Submission Regarding the Proposed Dubbo Zirconia Project

The following provides the submission of Taronga Conservation Society Australia (TCSA) in relation to the Environmental Impact Statement for the proposed Dubbo Zirconia Project.

OBLEY ROAD ALIGNMENT INVESTIGATION & INTERSECTION TREATMENT CONCEPT

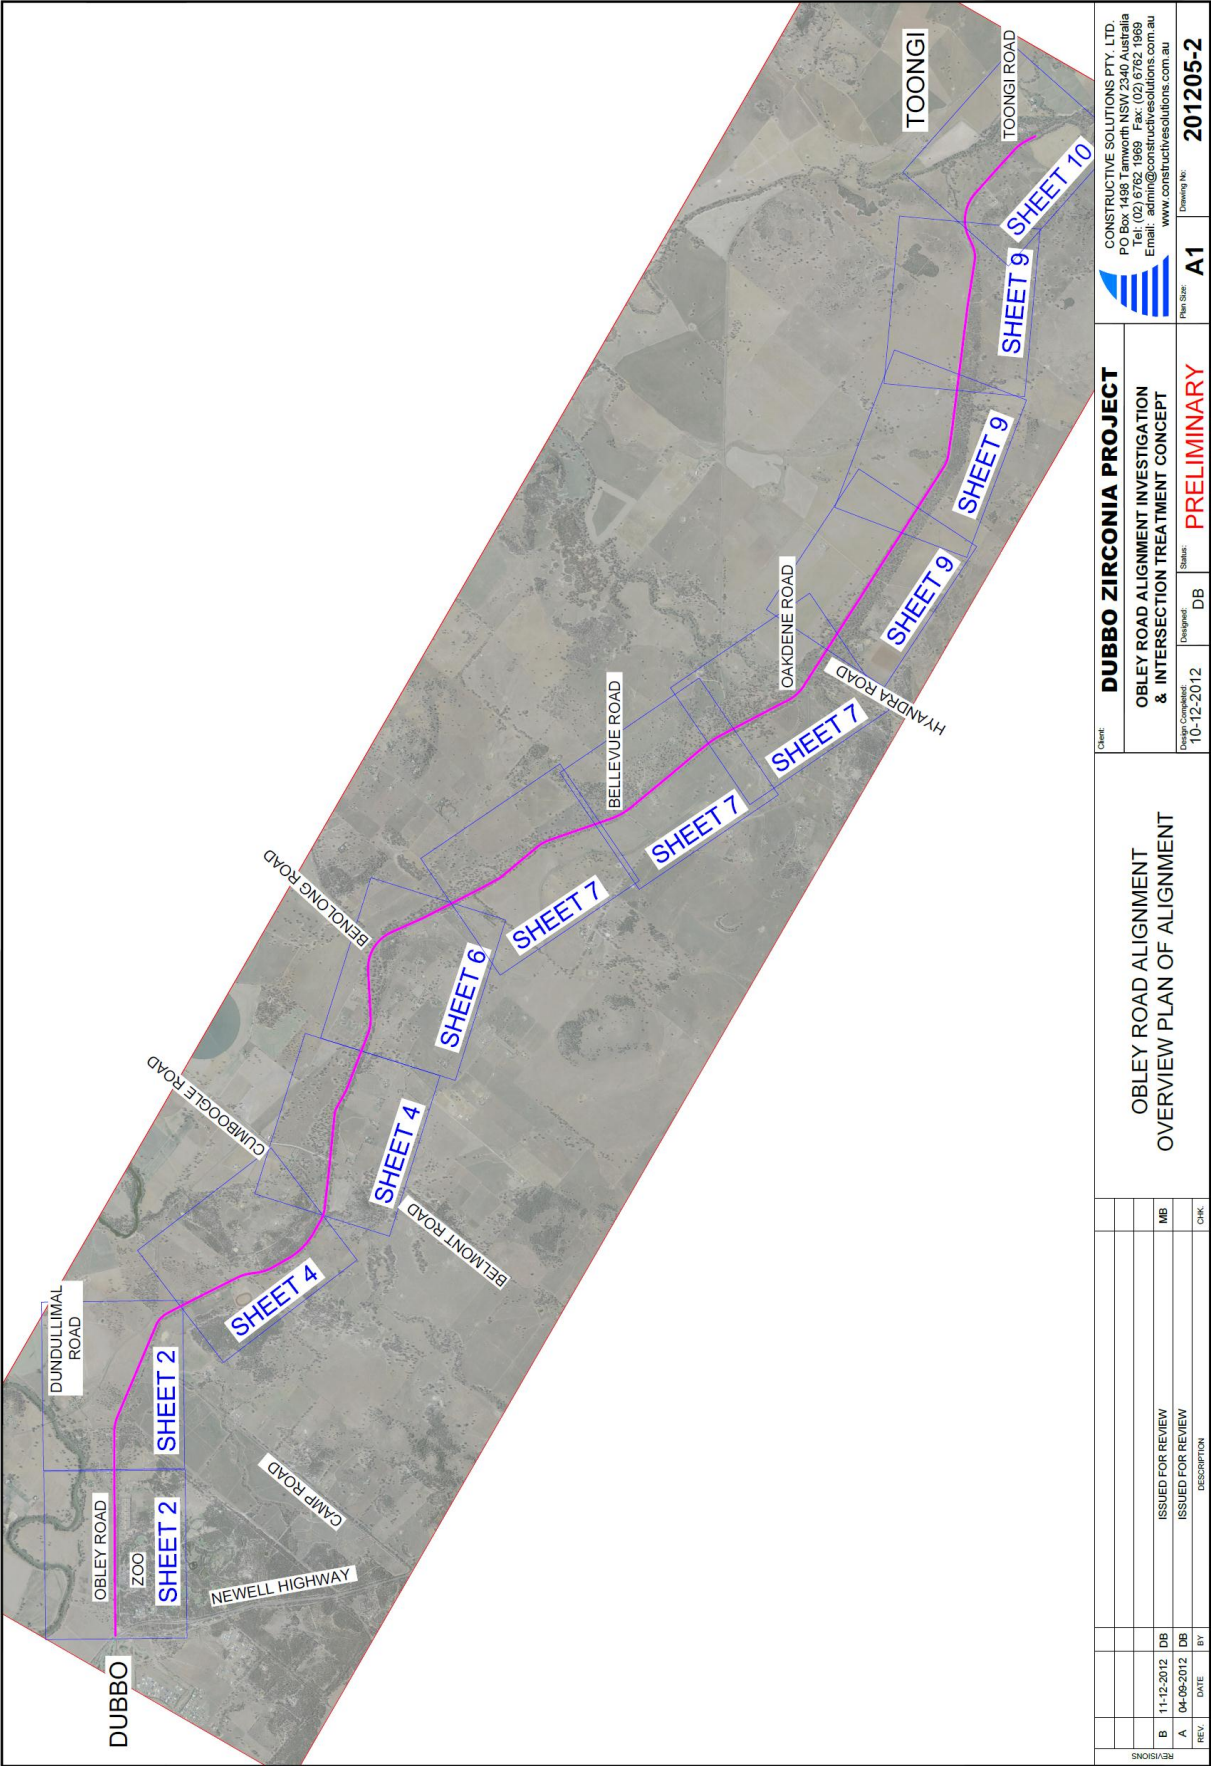
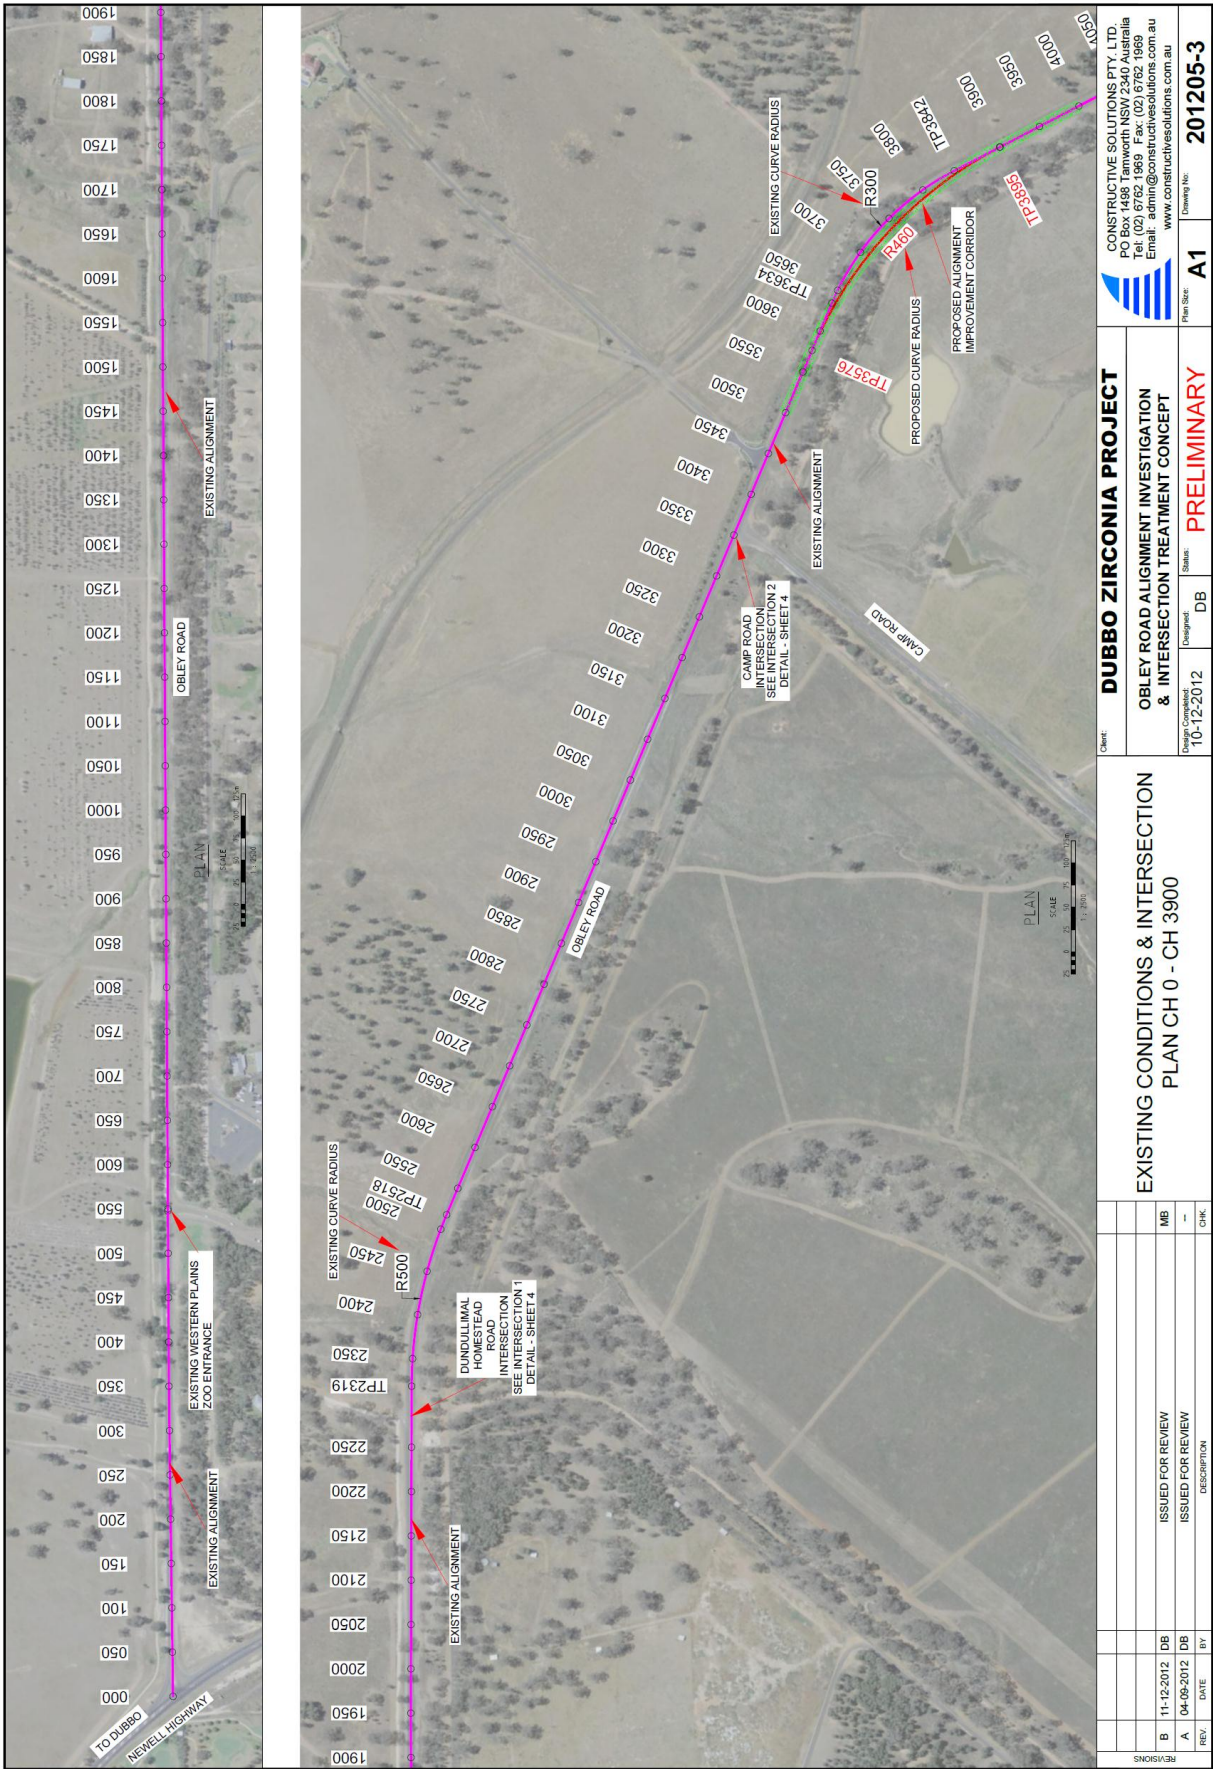
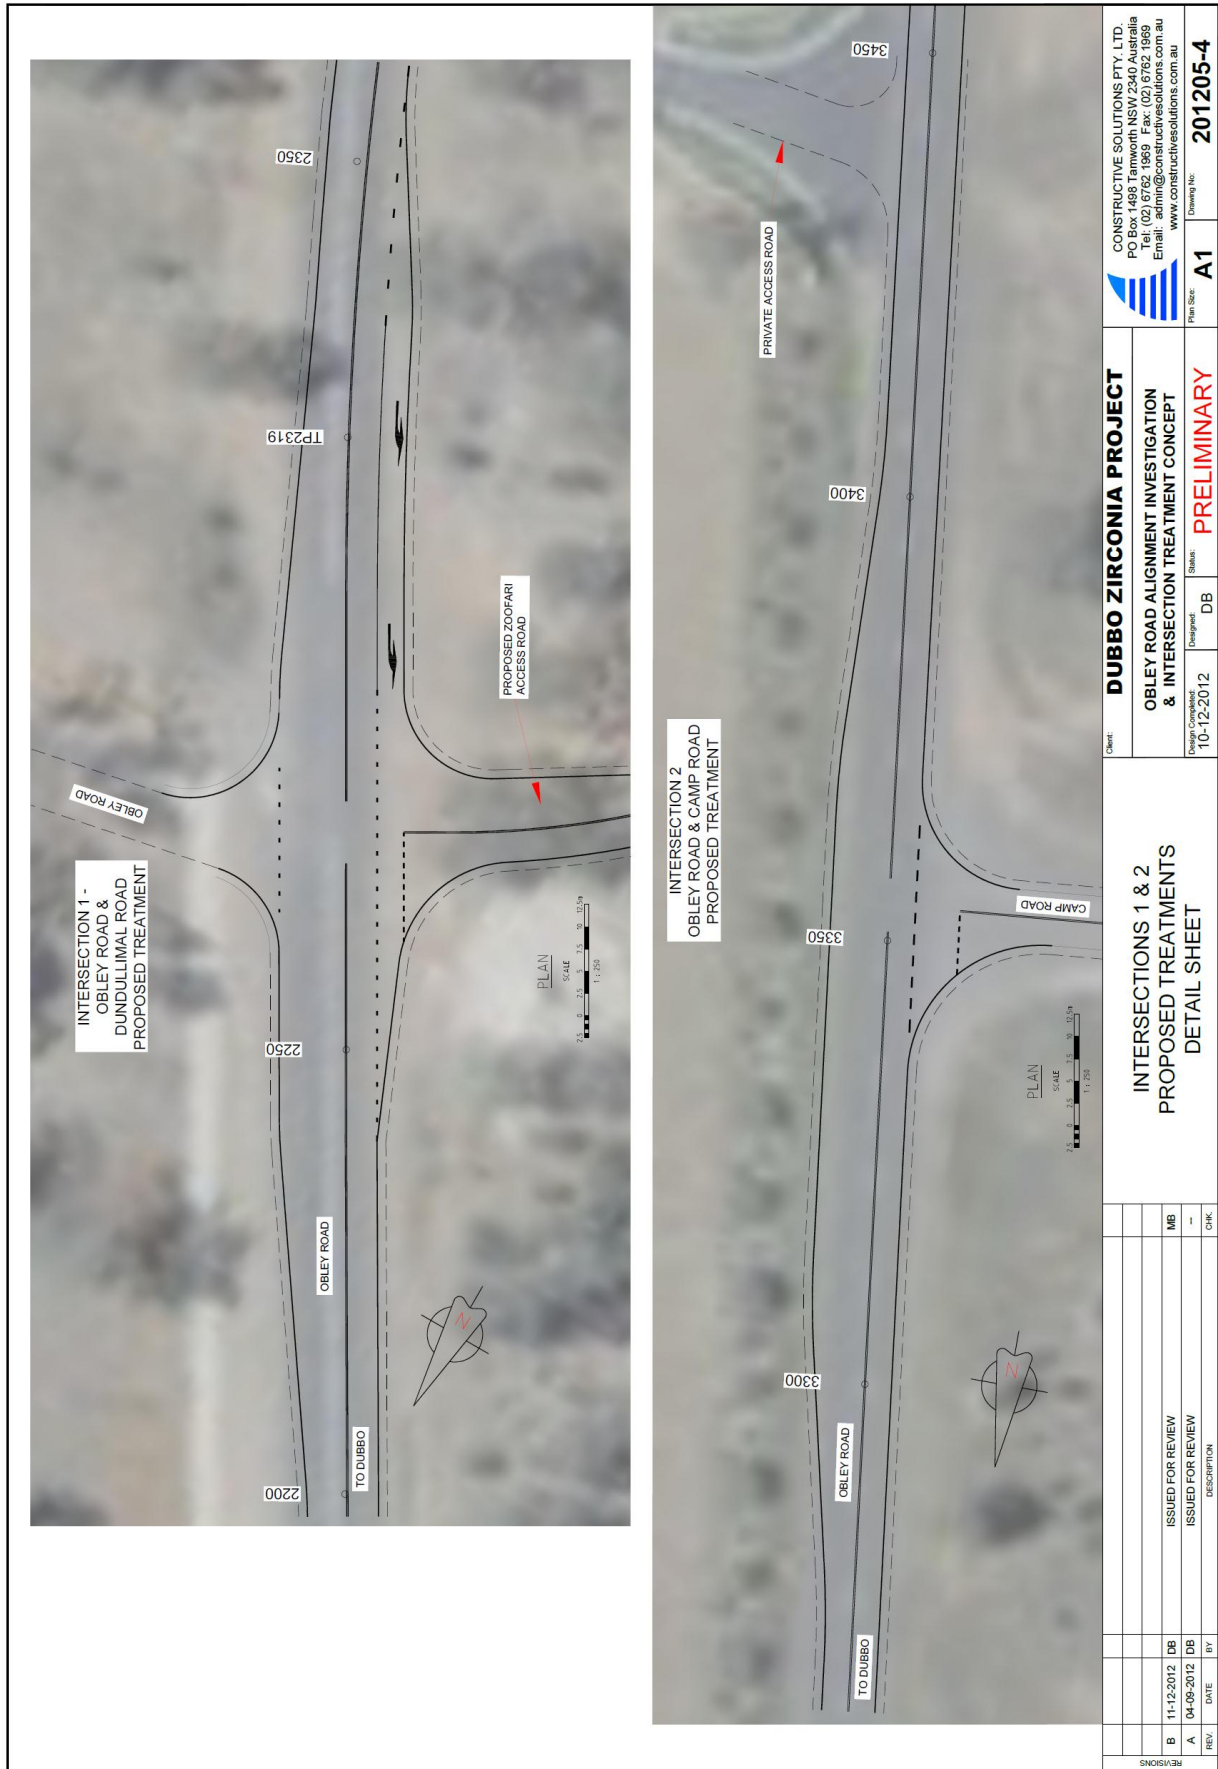
The EIS indicates that there would be various upgrades to Obley Road under the proposal, including alignment adjustments to meet Austroads *Guide to Road Design* requirements for a 100km/hr speed limited road, pavement improvements, and the establishment of a 9m wide pavement seal. No specific improvements to Obley Road adjacent to the main operational area of the zoo, are indicated in Figure 2.4 of the EIS

It will be vital to minimise the risk of conflict between vehicles associated with zoo visitation and those associated with the proposal. TCSA therefore suggests that the standards to be adopted for Obley Road between the Newell Highway and the zoo entrance, should be higher than those adopted for the remainder of Obley Road. Specific improvements requested by TCSA for this section of Obley Road are:

- The establishment of a standard 12m wide road cross section based on Austroads guidelines for roads carrying more than 3000 vehicles per day. This would comprise 2 x 3.5m wide lanes in each direction, 2 x 1.5m wide sealed shoulders, and 2 x 1m unsealed shoulders on the outside of the sealed shoulders.
- Clear road and edge line delineation.
- Addressing the presence of clear zone hazards such as trees (potentially through minor adjustments to the road alignment and/or safety barriers)
- Upgrading of the cyclist/pedestrian crossing on Obley Road near the zoo entrance. The most appropriate solution may be grade-separation

(underpass), however TCS acknowledge this would require discussion between the TCSA, Australian Zirconia Ltd, Council and RMS to identify the optimum solution.
